Application for a Non-Material Amendment Following a Grant of Planning Permission

Erect a first floor side (LHS) extension and a part 2-storey/part single storey side (RHS) extension, and a porch to front of existing dwelling, involving the demolition of existing garage and carport.

F/YR23/0193/F

**RoofPlan-Rev B**  
**Existing and Proposed**

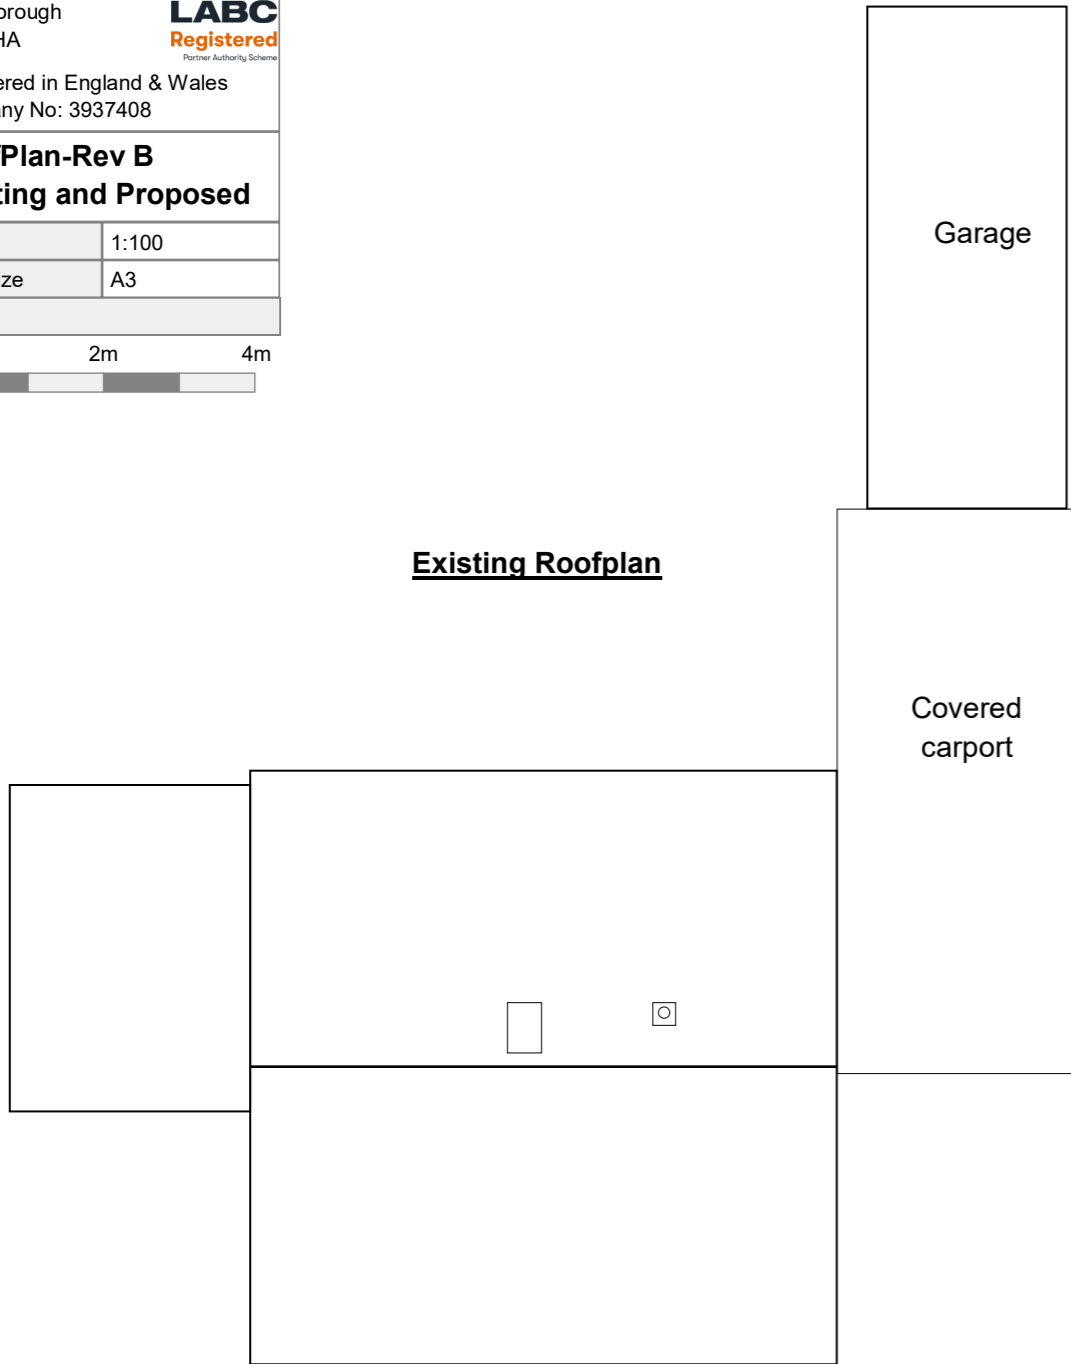
Reduction in projection of rear single storey extension from rear wall of house.

Registered in England & Wales Company No: 3937408	
Site Plan	
Existing and Amened	
Scale	1:200
Print Size	A3
Scale

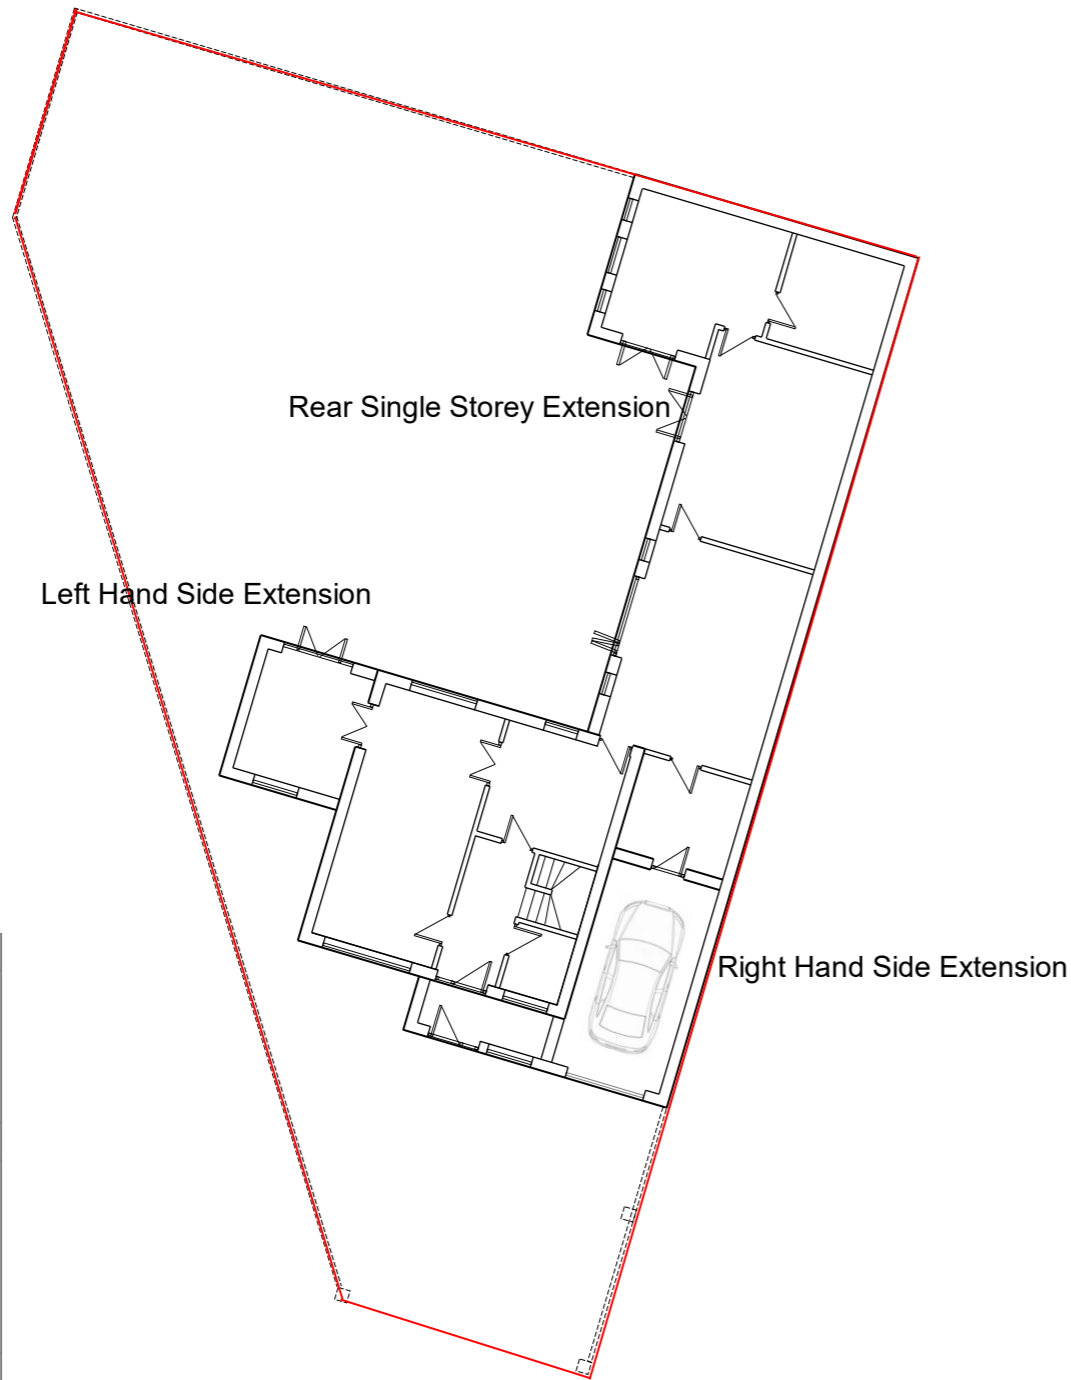
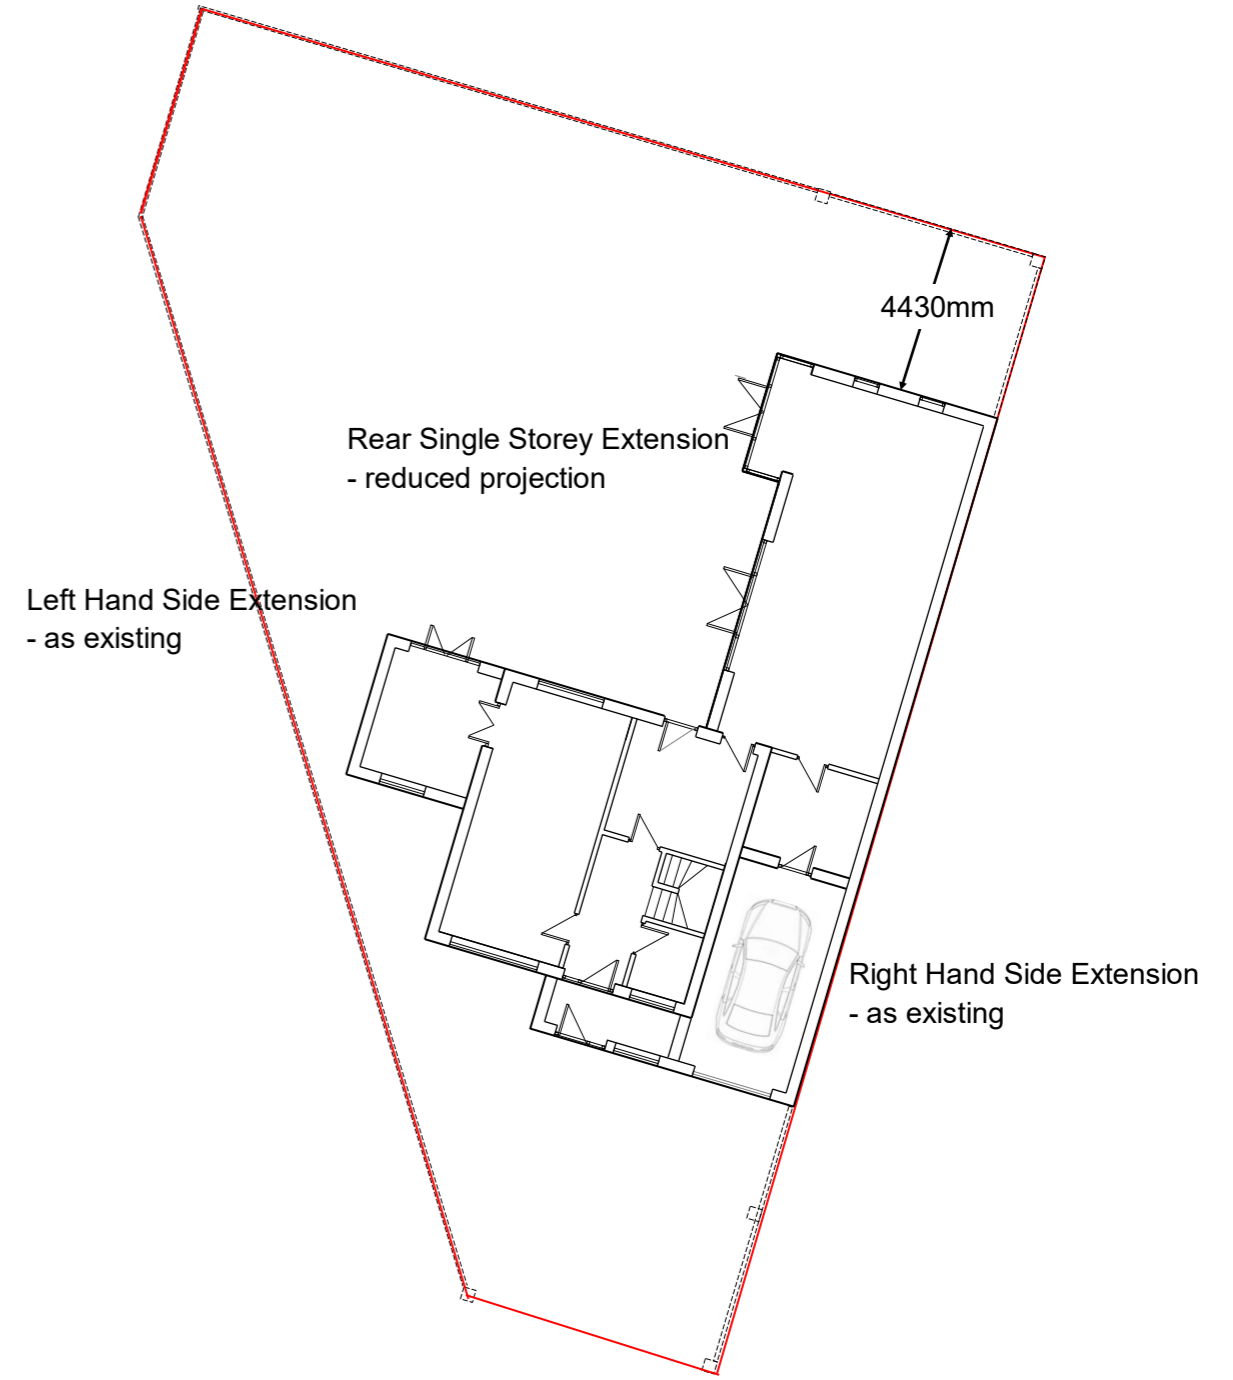
Forced change to design due to location of public sewer that passes across rear of site (although not actually serving the site itself).

Anglian Water unwilling to agree a Build Over Agreement, but have approved a Build Near Agreement.

Projection of rear annexe from existing rear wall of house reduced by over 4m in agreement with Anglian Water.
